## HISTORIC BUILDINGS AND CONSERVATION ADVICE

### **RE: St Thomas A Becket Northaw Road West Northaw Potters Bar EN6 4NW**

The application is for: Demolition of existing external redundant boiler room

○ IMAGE OF REDUNDANT BOILER ROOM

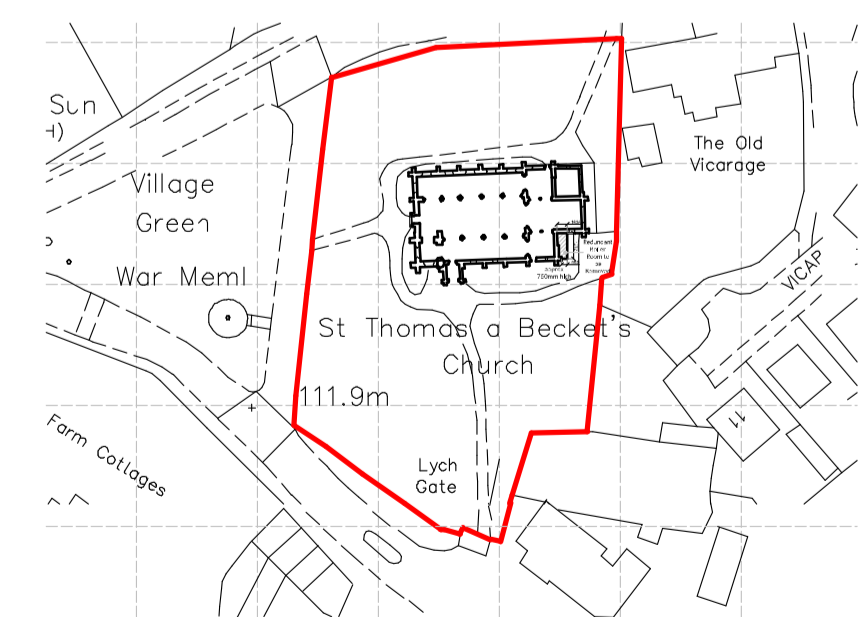
There is no objection to the demolition of the boiler room. The boiler room is shown on historic OS maps. However, it is apparent that the boiler room has had considerable modern alteration and that the alteration has led to an untidy appearance that does not complement the building. Its removal would also prevent any further damage being caused to the south chapel.

Were permission to be granted, I request that a condition be added: A method statement detailing the works to repair the wall once the boiler room is demolished, including the details of new materials, and details of the mortar mix, shall be submitted to and approved in writing by the Local Planning Authority prior to the commencement of works.
